WEST SUSSEX COUNTY COUNCIL CONSULTATION

TO:	Arun District Council FAO:Ms Myer
FROM:	WSCC - Highways Authority
DATE:	24 April 2020
LOCATION:	Tyrone House Norton Lane Chichester PO20 3NH
SUBJECT:	AL/29/20/PL Demolition of existing house & outbuildings & erection of 1 No. dwelling & detached garage. This application is CIL Liable.
DATE OF SITE VISIT:	n/a
RECOMMENDATION:	Advice
S106 CONTRIBUTION TOTAL:	n/a

-  Widened entrance to site
-  Proposed new dwelling
-  Proposed new outbuilding (garage)
-  As permitted AL/105/19/HH

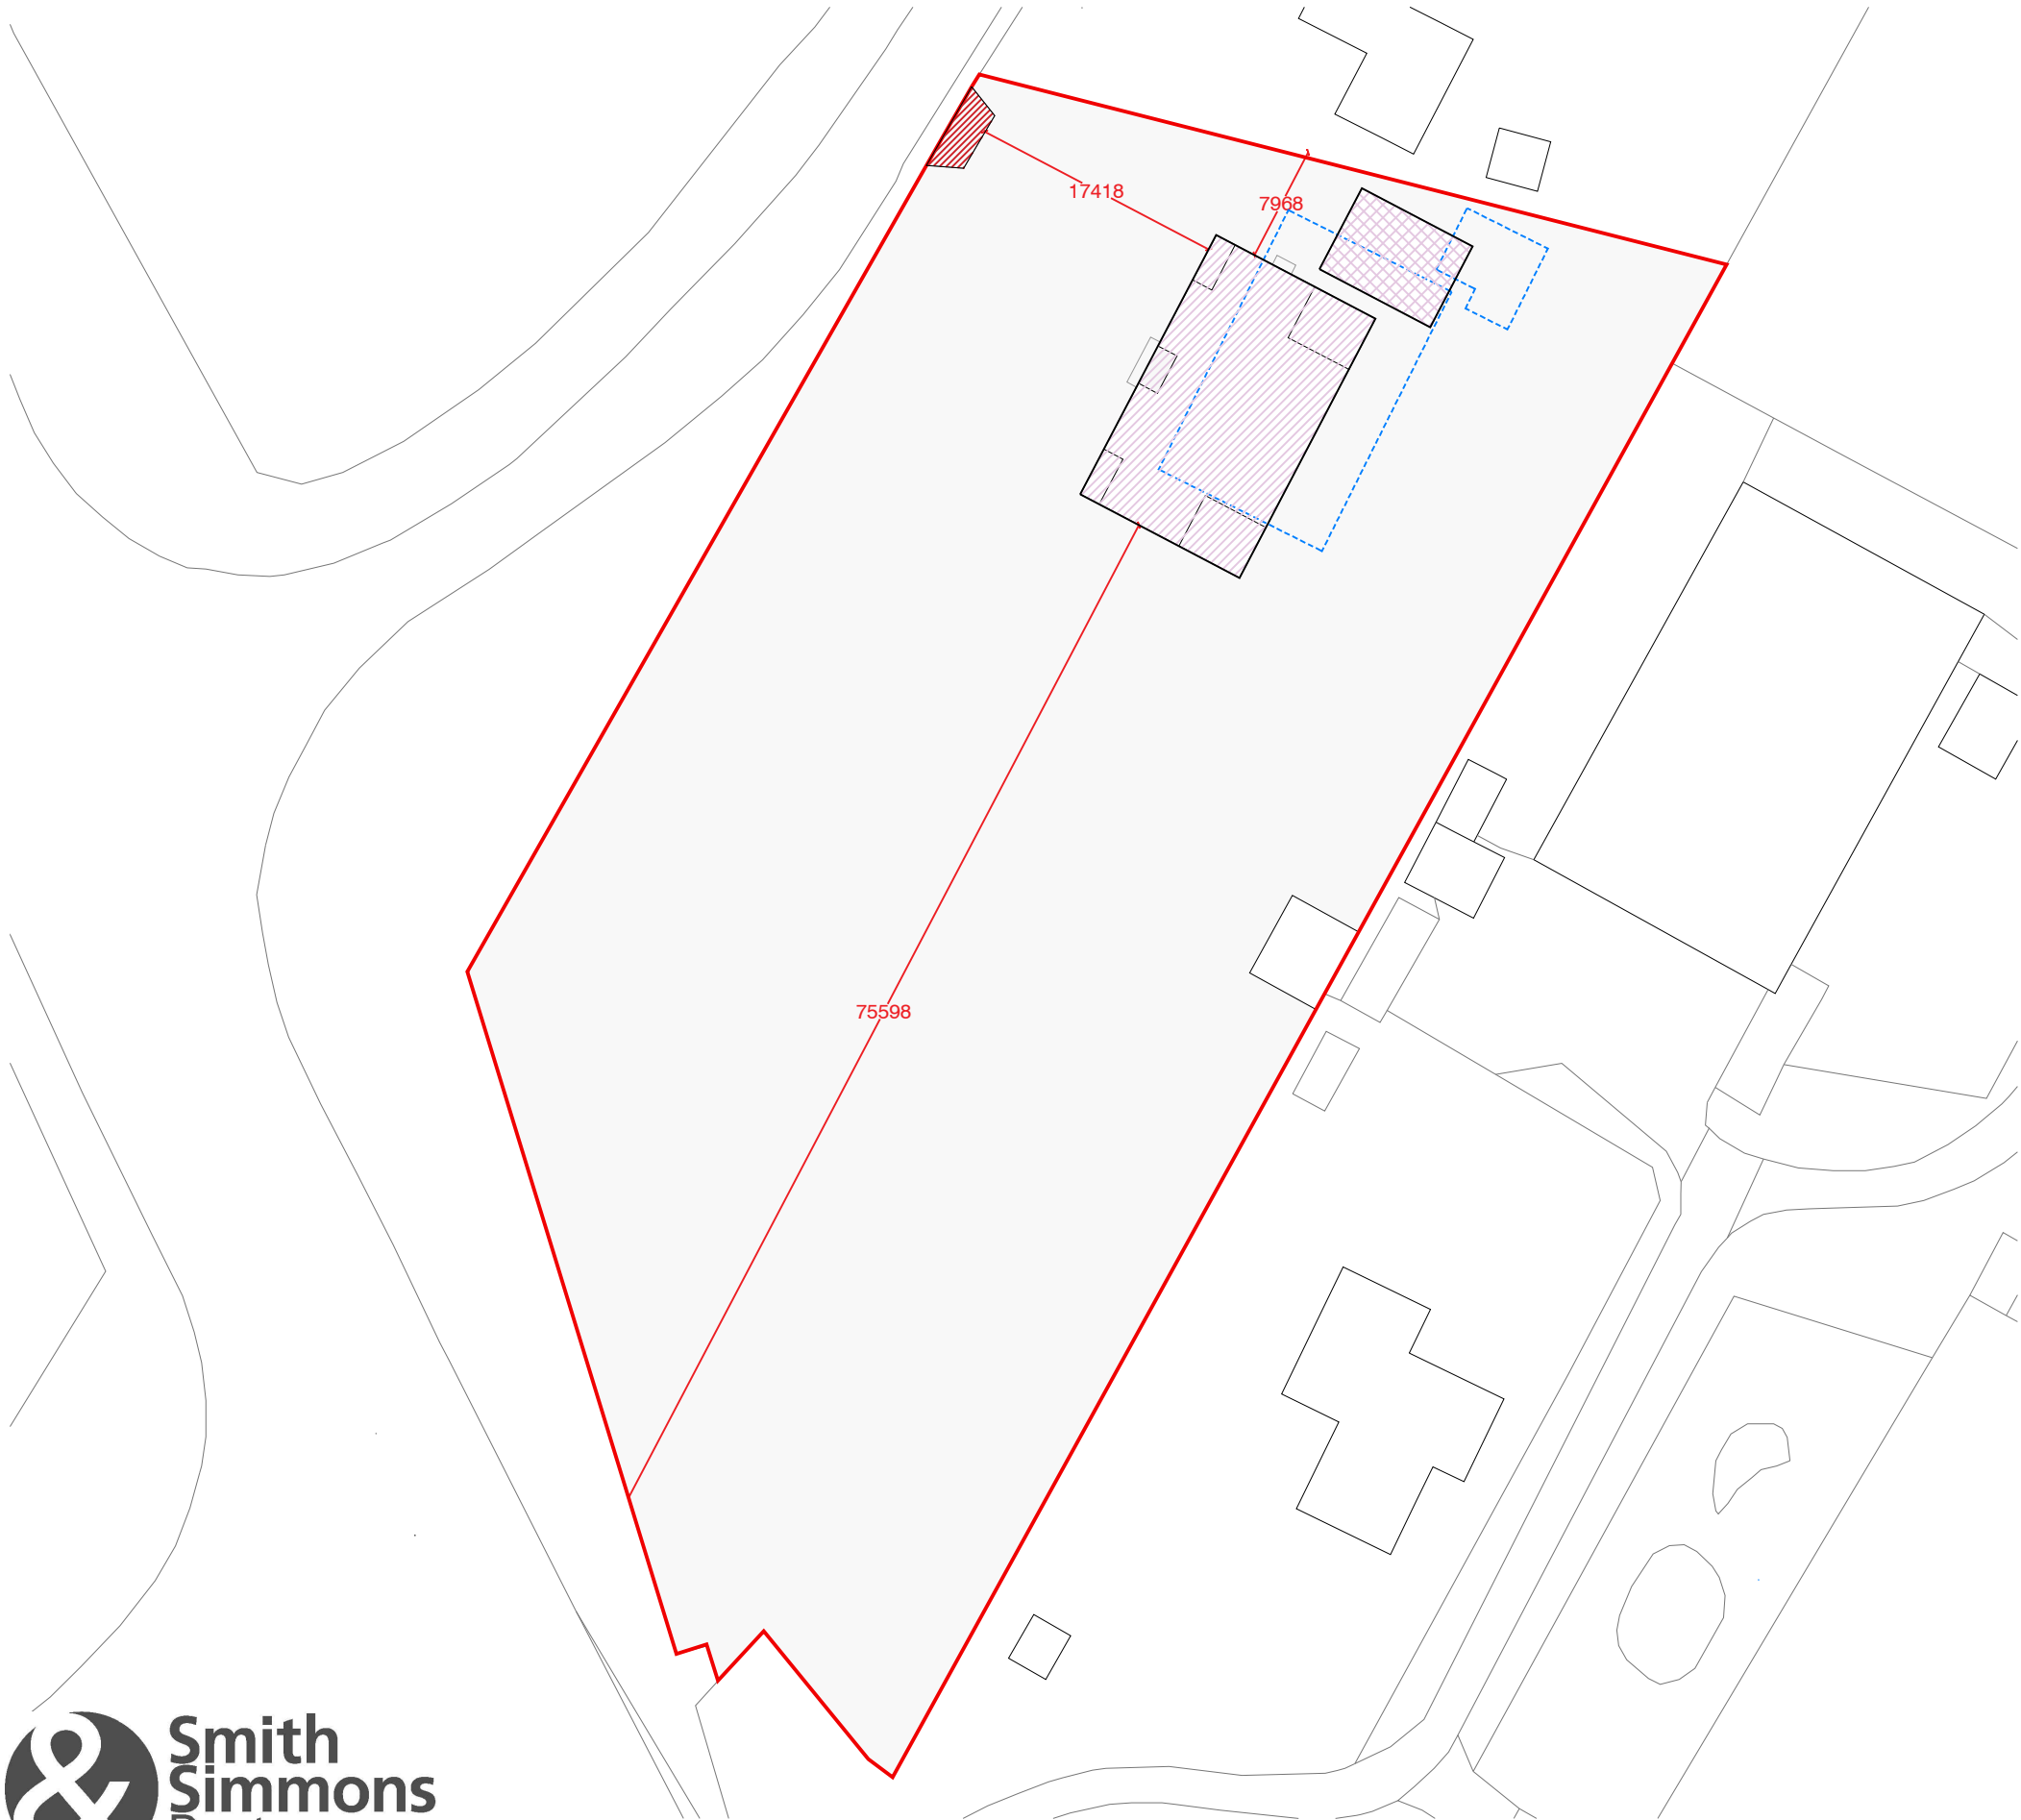
Vehicular access to the site will be utilised through the existing access onto Norton Lane. The proposed widening works will result in total of 6m access. The proposed access works must be implemented under a licence obtained by WSCC to a specification agreed with them.

Visibility splays appear restricted due to the presence of the hedge on both sides of the access, however weight is given to the fact that the access is existing and it has been operating for some time without any evidence of safety concern.

The application form states that 6 parking spaces will be provided for the proposed dwelling. Some of these spaces have not been demonstrated on the submitted plans. The WSCC Car Parking Demand Calculator (PDC) would expect at least 3 parking spaces to be provided for 4+ dwelling in this location.

The LHA is satisfied that the expected parking provision can be accommodated within the driveway which will be enlarged as part of the proposal. Details of this can be secured via planning condition.

No part of the development shall be first occupied until such time as the vehicular access serving the development has been constructed in accordance with the details shown on the drawing titled Block Plan and numbered 101 DP.

No part of the development shall be first occupied until the car parking spaces have been constructed in accordance with plans and details to be submitted to and approved in writing by the Local Planning Authority. These spaces shall thereafter be retained at all times for their designated use.
